Appendix D – Detailed Response to Submissions

Table 1 DPHI Request for Information

Table 2 Agency Submissions

Foundations and ground floor structure to Harris Street extension.

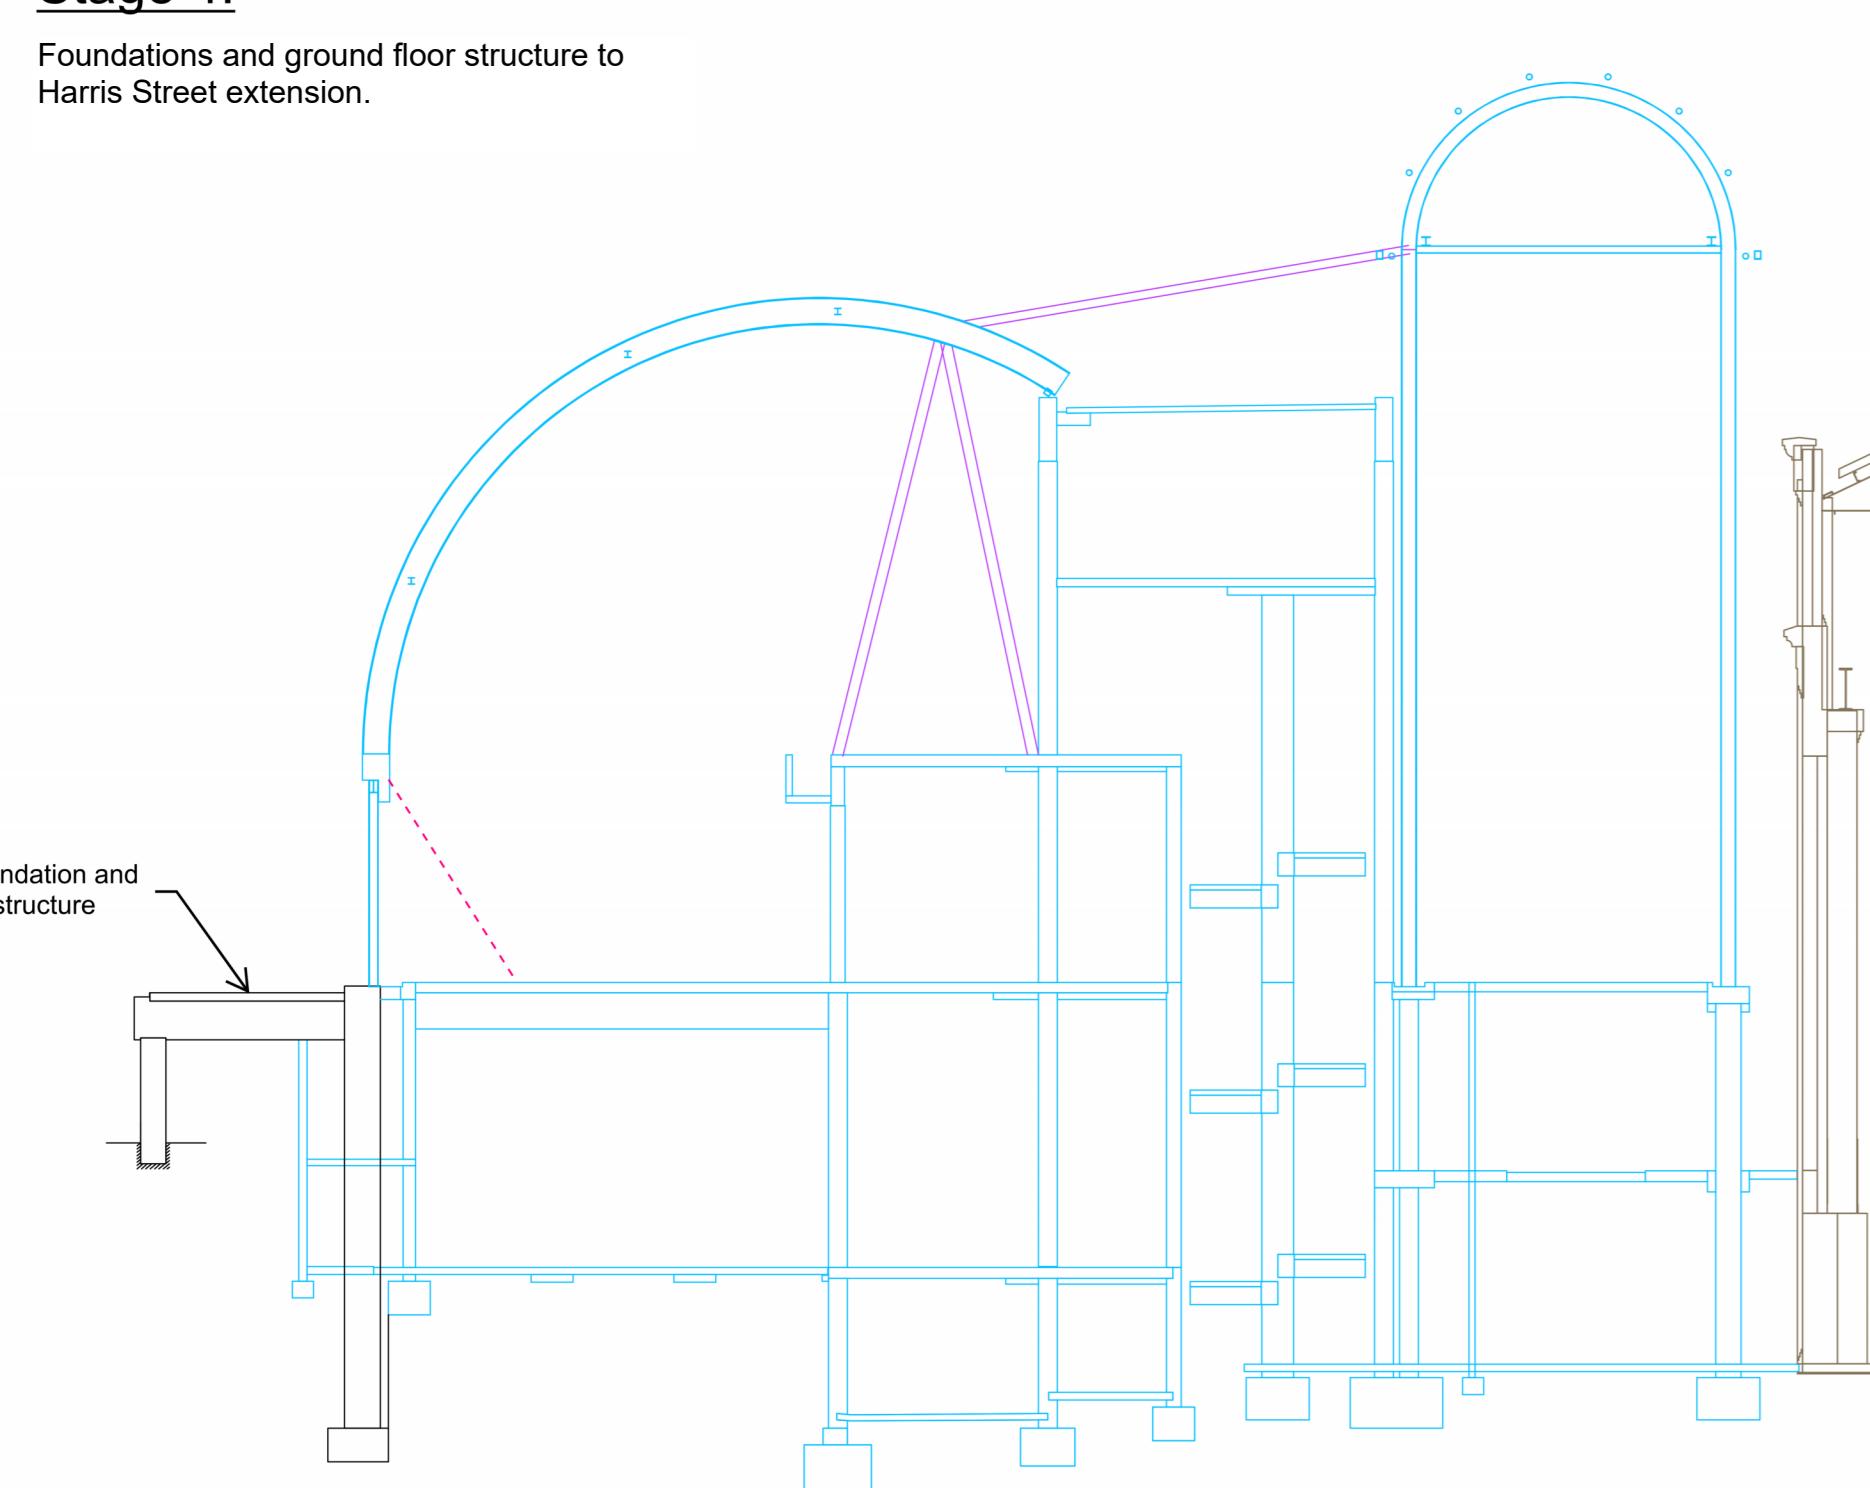
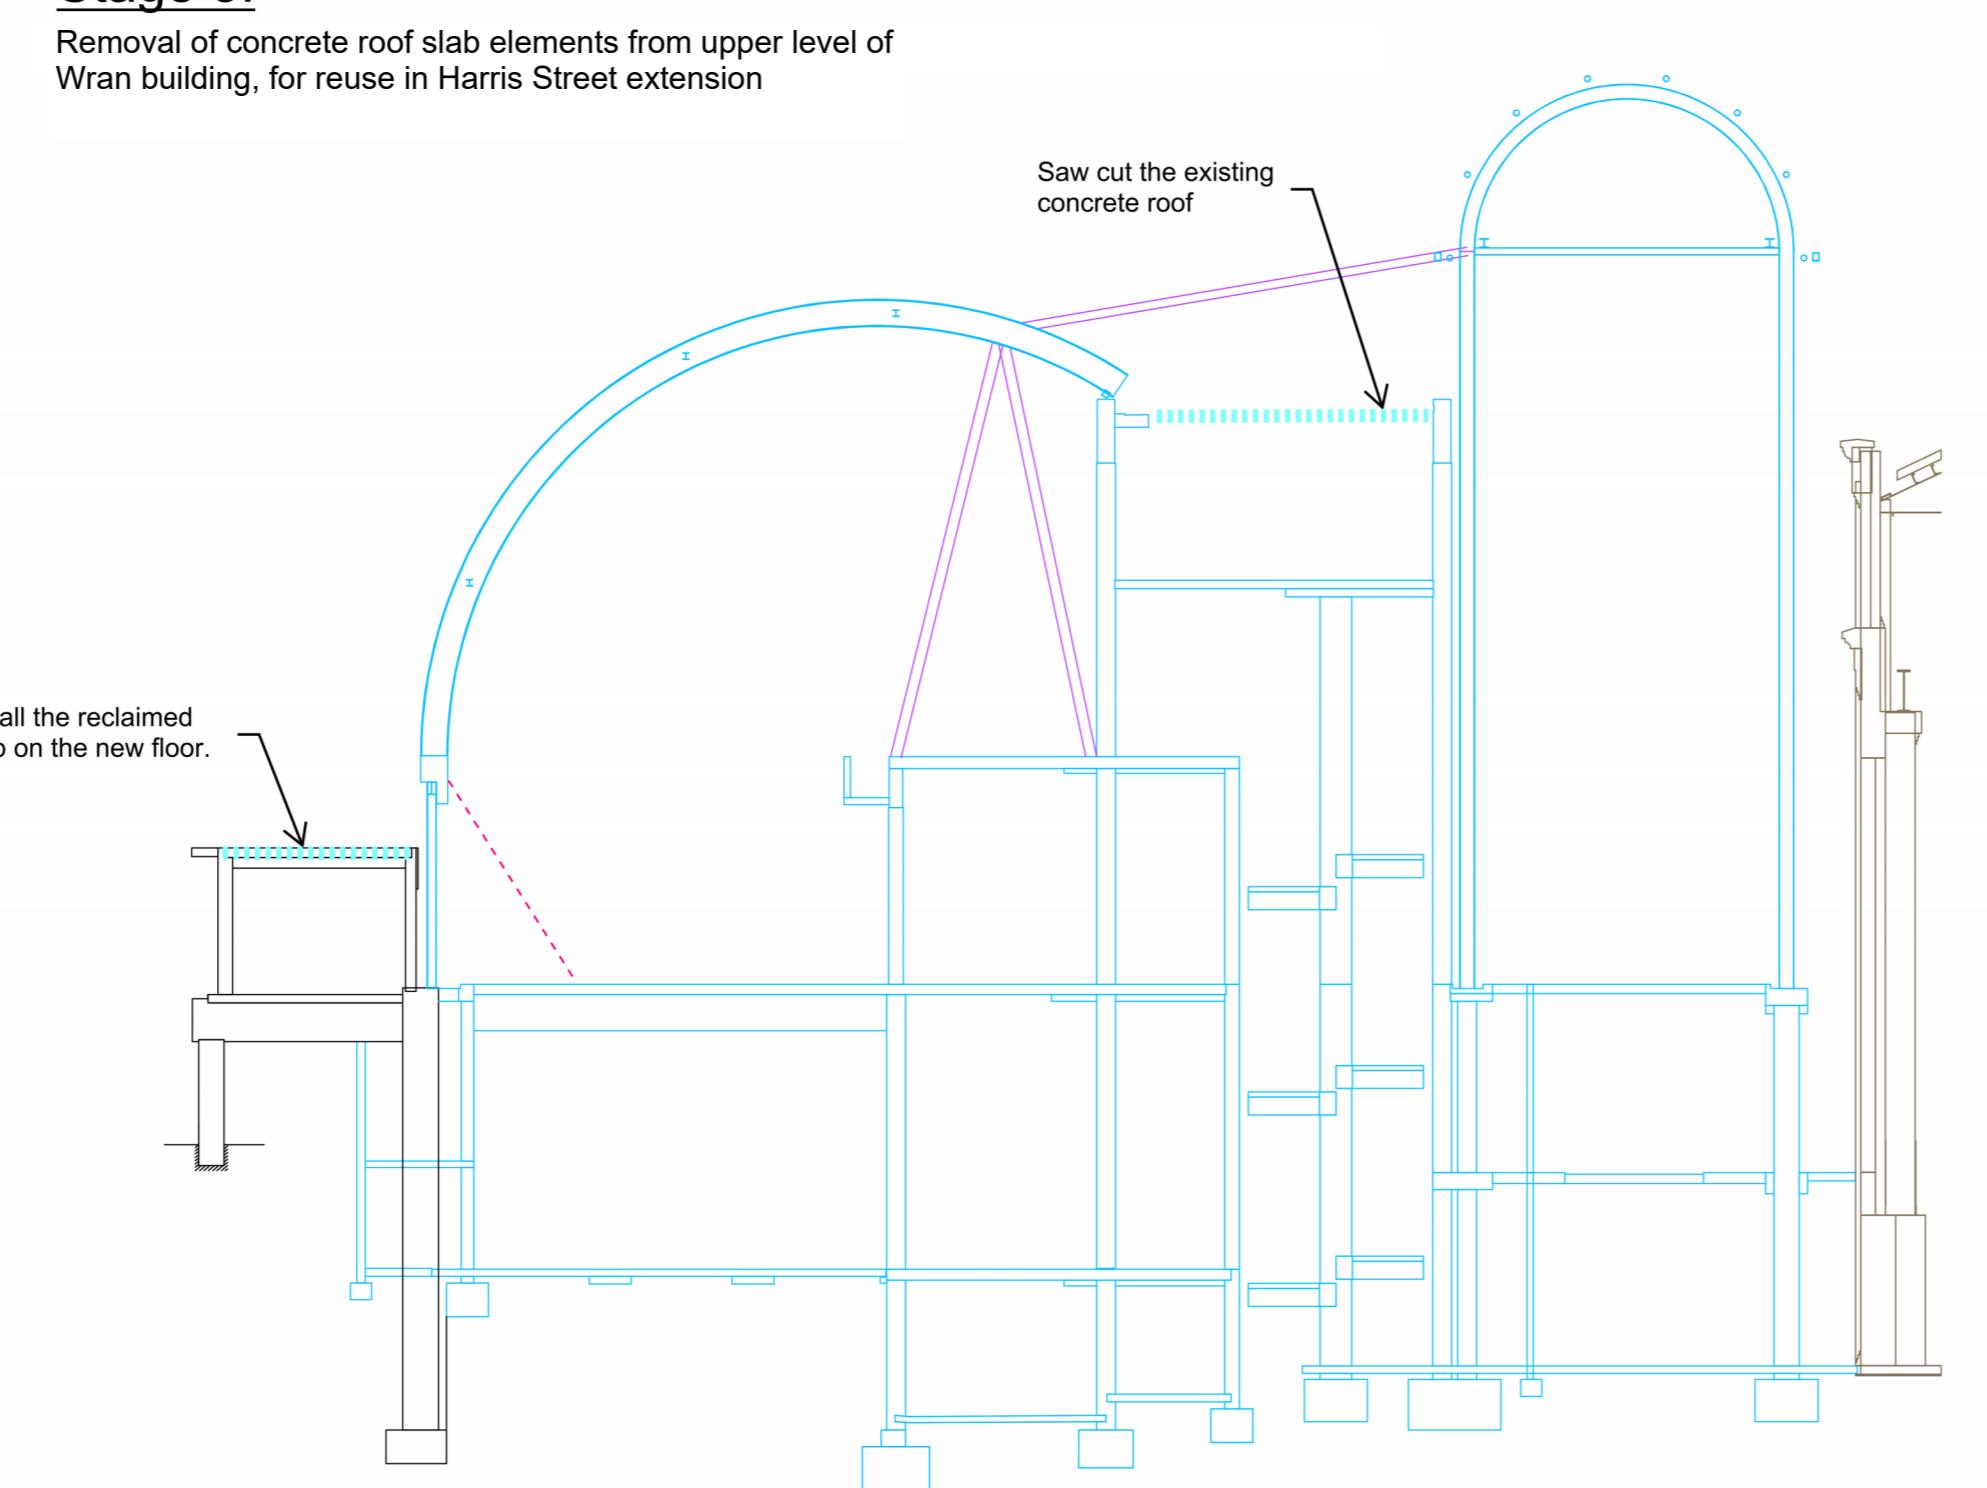
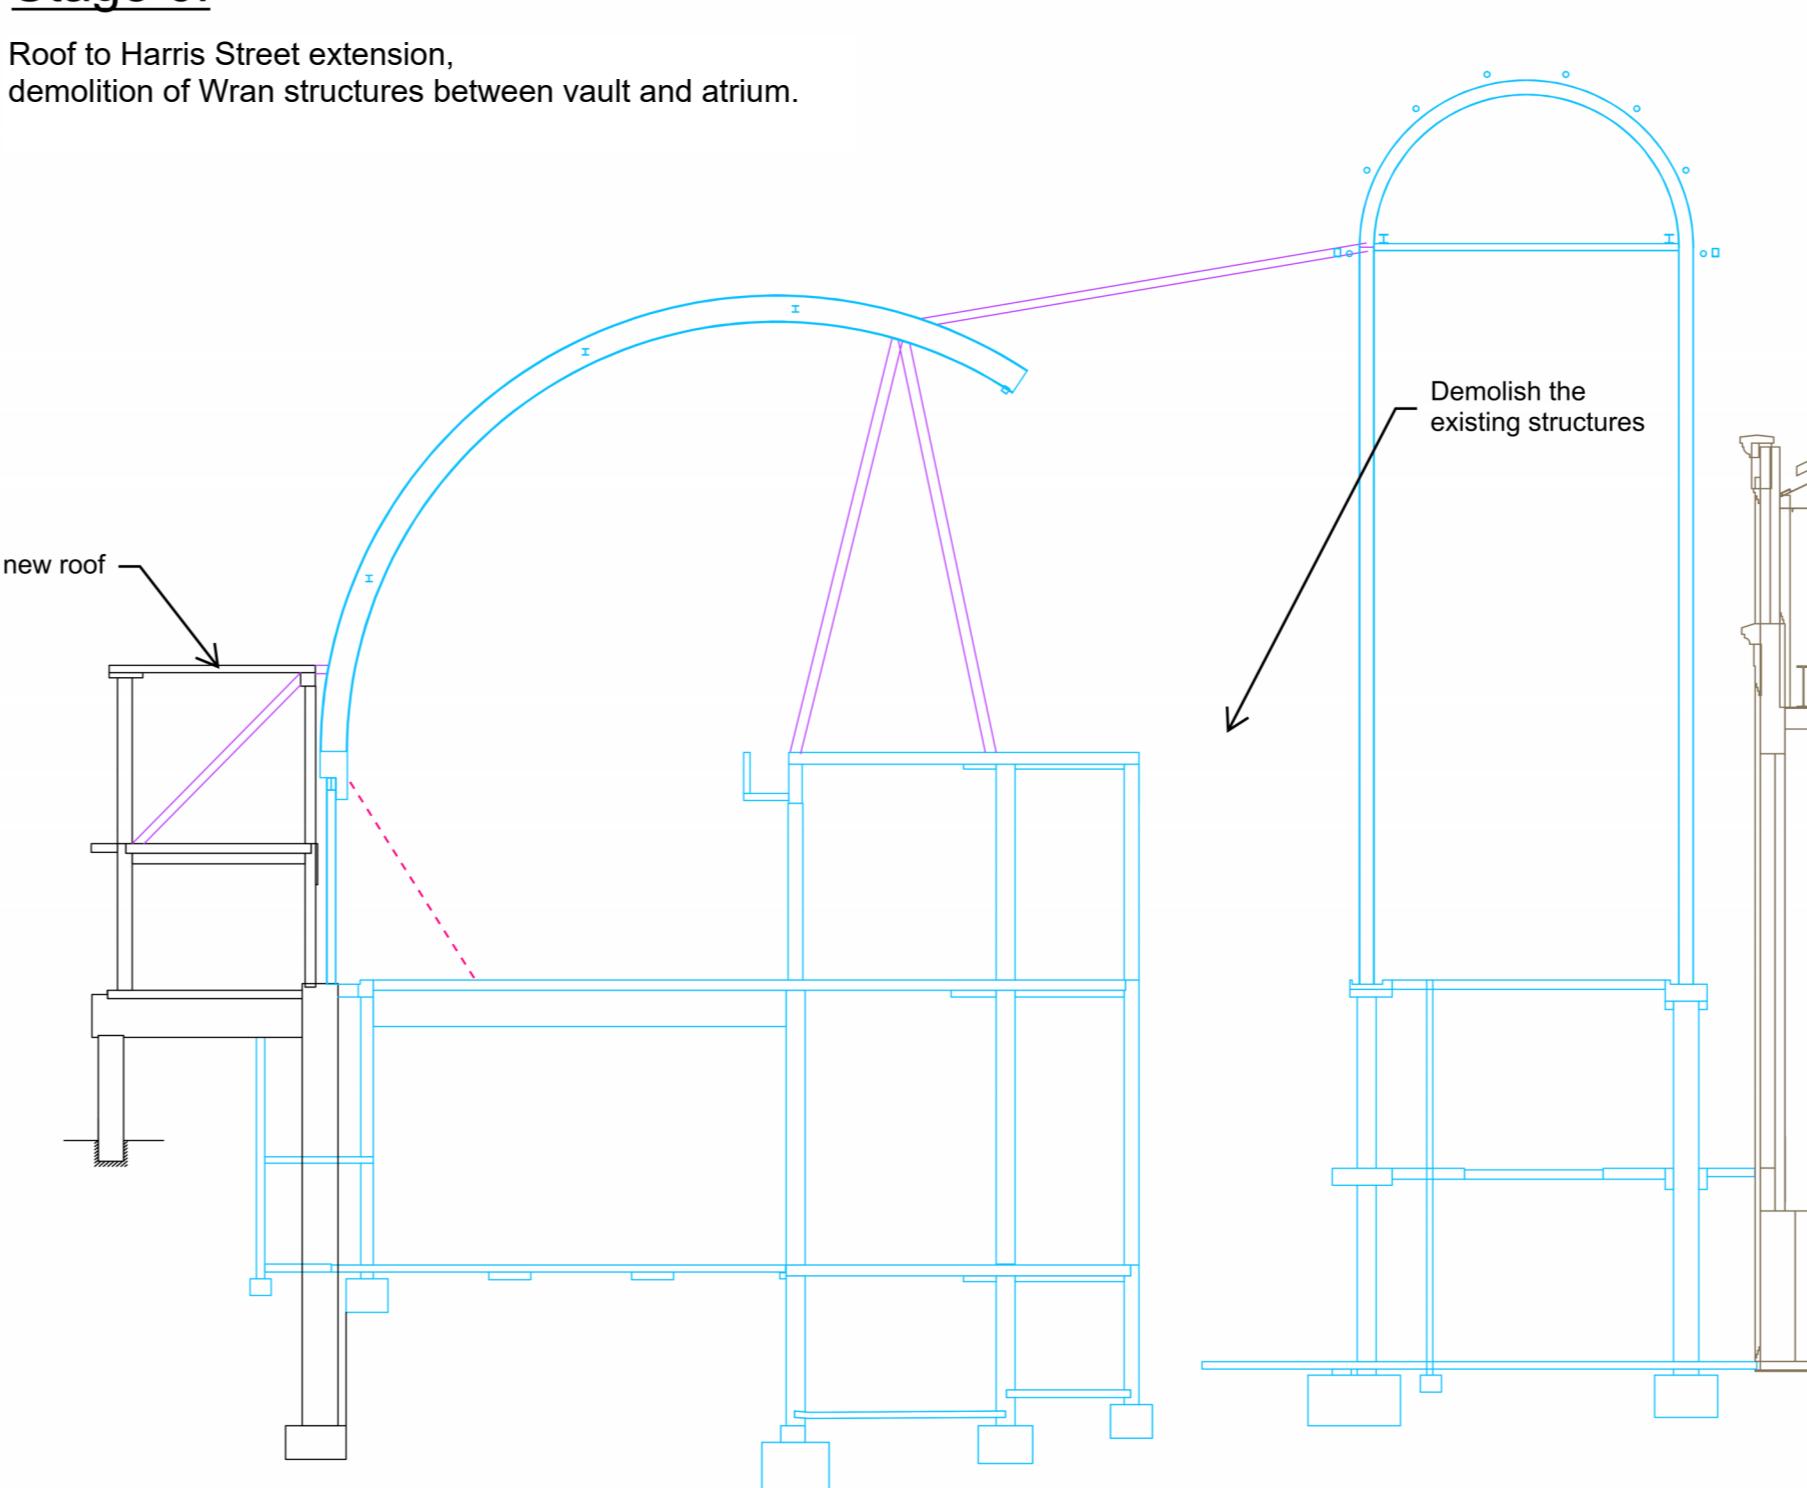
<ul style="list-style-type: none"> - Clarification is required as to whether the intent is to retain the existing roof form and structure and how this would be extended to complete the arch of the barrel. The materiality of the roof is also to be clarified with the continuing use of a high durable long life; lightweight metal roof preferred. Galvanic reactions between dissimilar metals must be avoided or managed. - The demolition of the lower-level colonnade associated with the Wran Hall allows creative industry spaces to be provided along and activate Harris Street. This is supported; however, the spaces would be disconnected from the Powerhouse Museum and servicing and waste removal needs to be further considered. 	<p>finishes. In relation to heritage impact, the amended HIS provides further assessment of these materials.</p> <ul style="list-style-type: none"> • Refer to Amended Design Report at Appendix F. • Servicing of the Creative Industries spaces will need to occur from the Harris Street frontage. The waste servicing requirements for the users of this space will be extremely low and comparable to a typical office use. Emptying of waste would occur on a daily basis by each tenant taking waste to the central waste room within the loading dock. It is expected that each tenancy will be provided with a 10L bin. • Waste reduction initiatives as part of the submitted ESD Report at Appendix BB of the EIS include a commitment to 80% of construction and demolition waste to be recycled by the head contractor.

CoS10	<ul style="list-style-type: none"> • Materials and Building Expression <ul style="list-style-type: none"> - There is only a very limited palette of materials shown on the architectural drawing set - The design report also includes garden mesh and aluminium cladding - The design report also references 'The new built form will be comprised of a mix of recycled and new bricks, brick slips, stone, ceramics, glass, metal cladding and class 2 in situ concrete and precast concrete.' - The proposed materials and finishes need to be further clarified and the drawings should be amended to clarify materials and key these to the elevations and sections. This is also requested to assist in assessing the potential heritage impacts of the additions. - The design of the Wran hall and galleria adaption is generally supported; however, more information is required to understand the amount of demolition and retention of structure. - The northern and southern ends of the Wran hall and the galleria are shown in elevations as brick. More information is required regarding the construction and structural delivery of brick ends to the existing steel super structure. The roof skin is also to be clarified, it is unclear from the renders, what this is intended to be. 	<ul style="list-style-type: none"> • The Amended Design Report at Appendix F to this Submissions and Amendments Report provides further details on the proposed materials and finishes. In relation to heritage impact, the Amended HIS (Appendix L) provides further assessment of these materials. Details regarding the extent of demolition of internal areas within the Wran Building are included within the Structural Sequencing diagrams contained at Appendix H to this Submissions Report.
